# D.B. Gray Engineering Inc.

September 12, 2024

**Re: 2506 Innes Road**

Our responses to your comments in a letter dated July 12, 2024 are below. Our headings and numbers correspond with the headings and numbers in your letter.

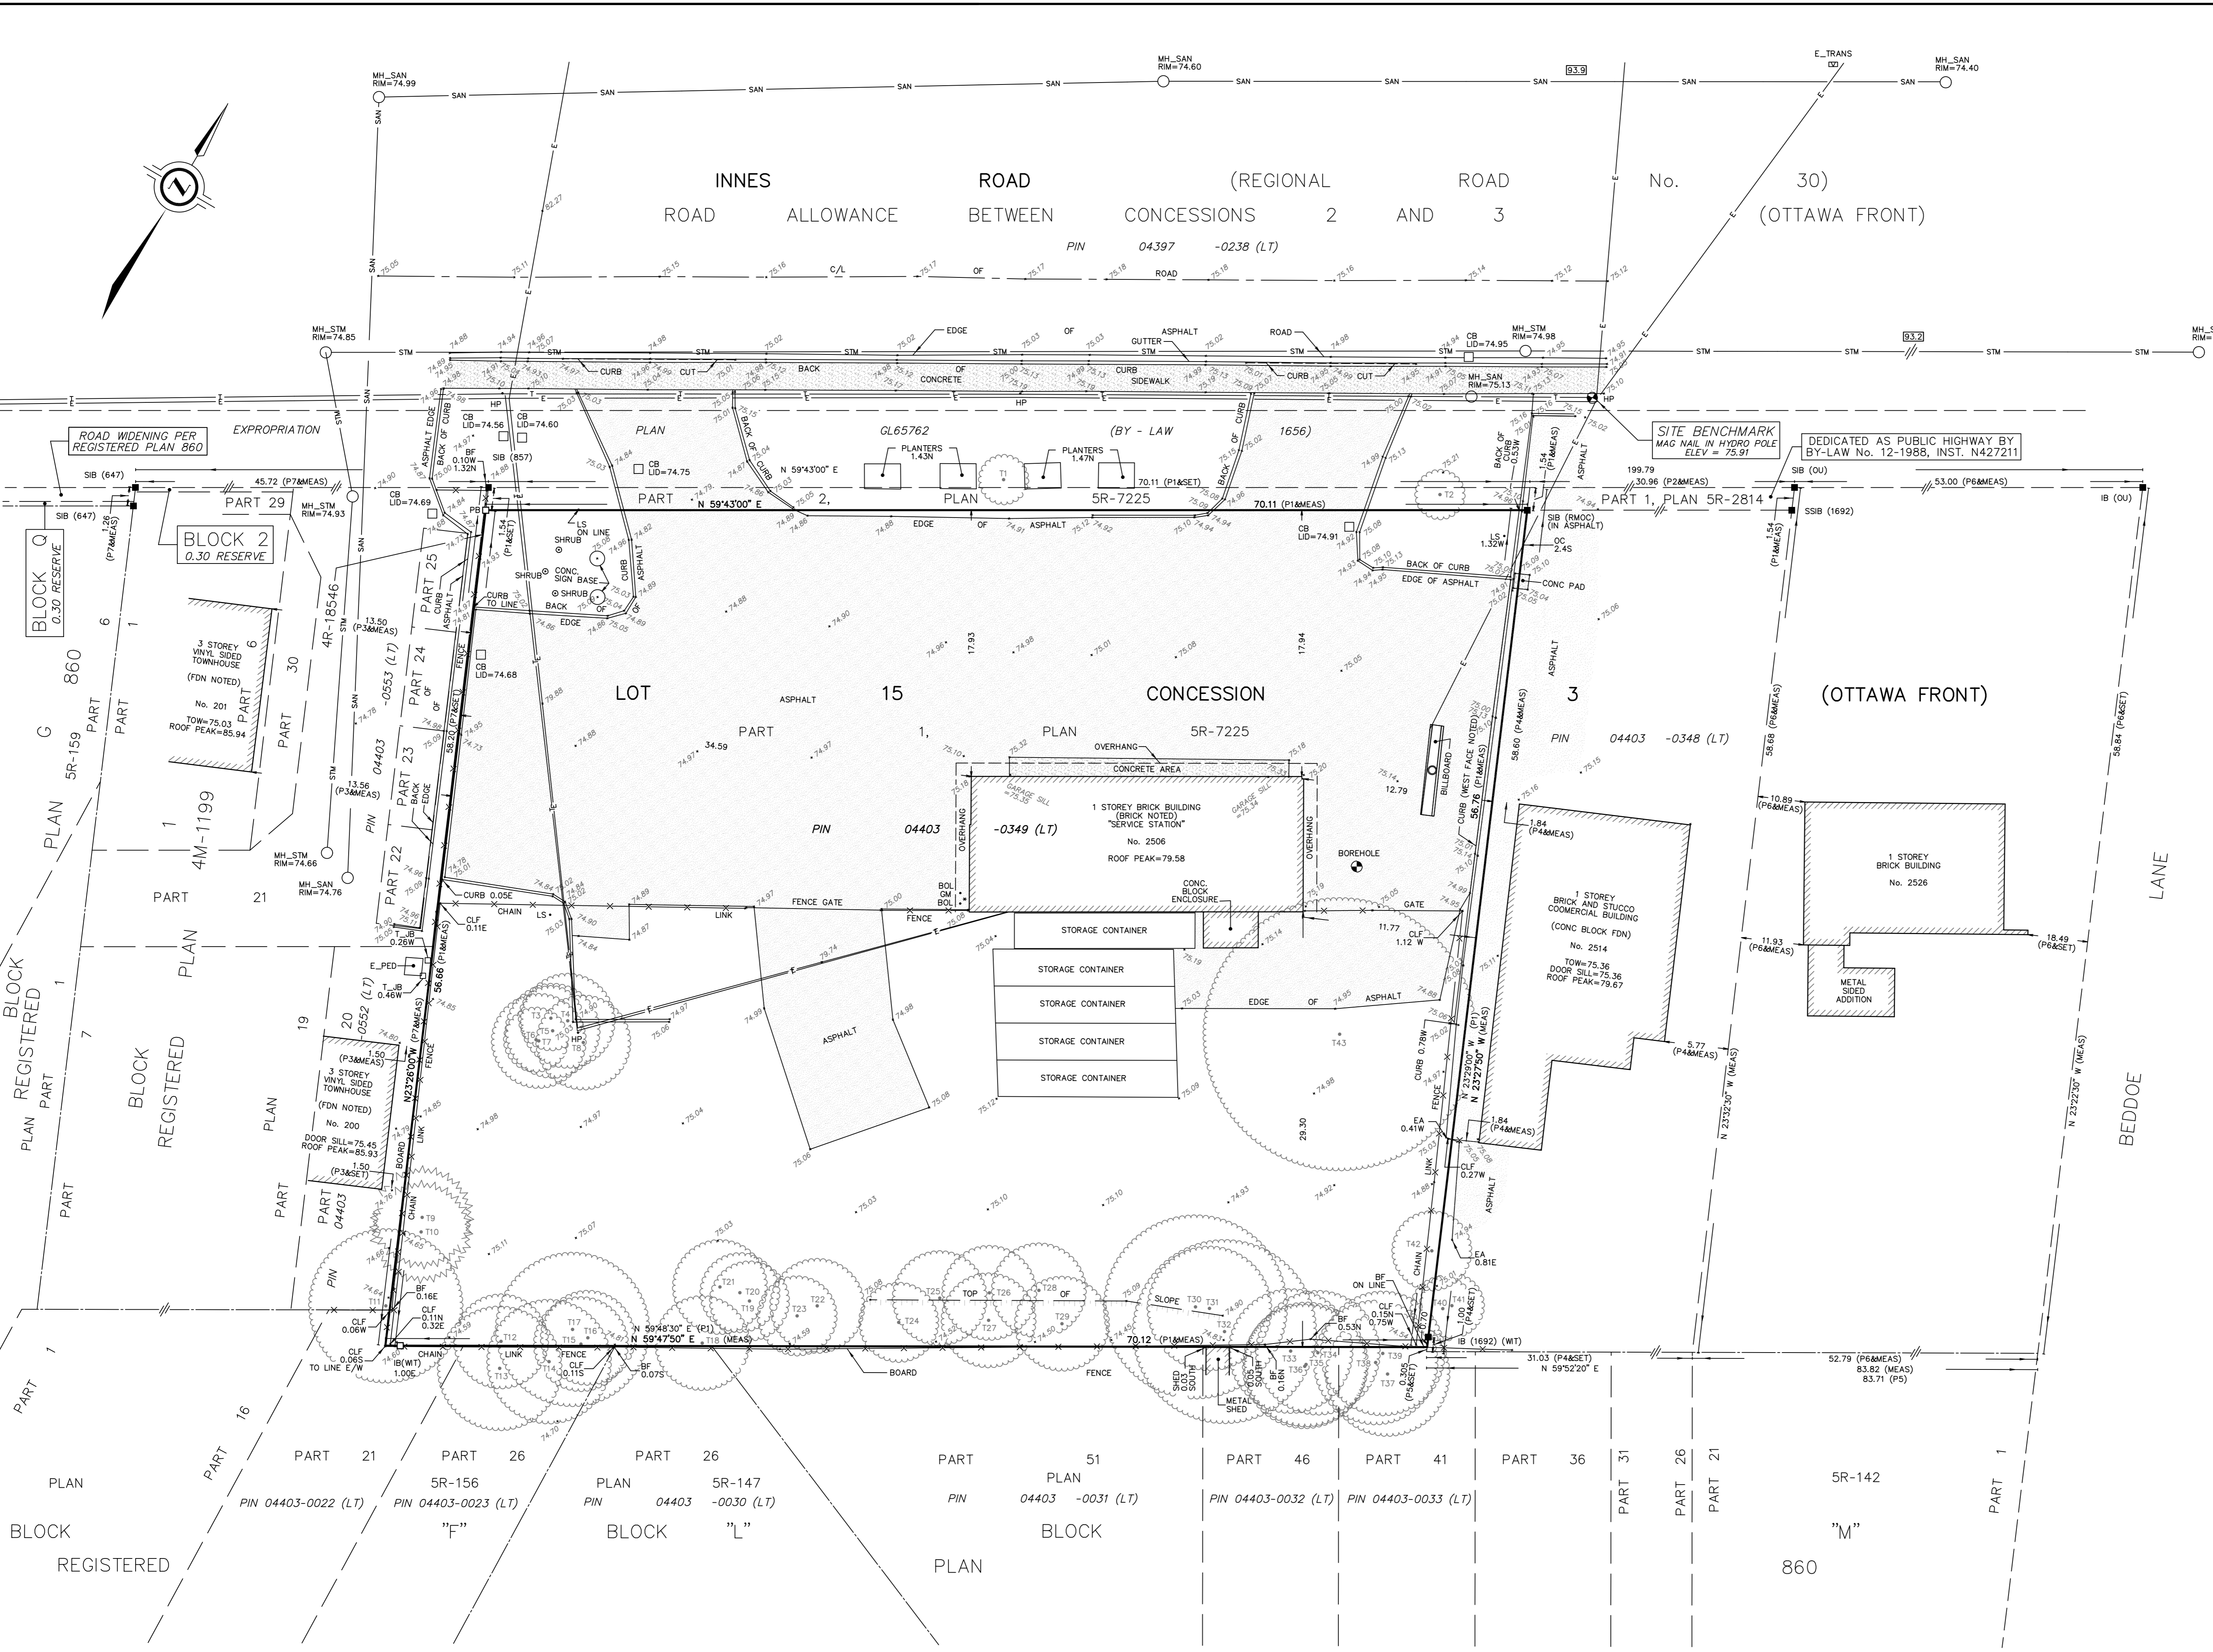
11. Added.
12. Note 1.3 on drawing C-6 already states *"SITE BOUNDARIES AND EXISTING GRADES AND OTHER FEATURES DERIVED FROM TOPOGRAPHIC SURVEY PREPARED BY J. D. BARNES LIMITED REF No. 23-10-085-00."* Topographic survey already states *"MTM ZONE 9, NAD 83"*
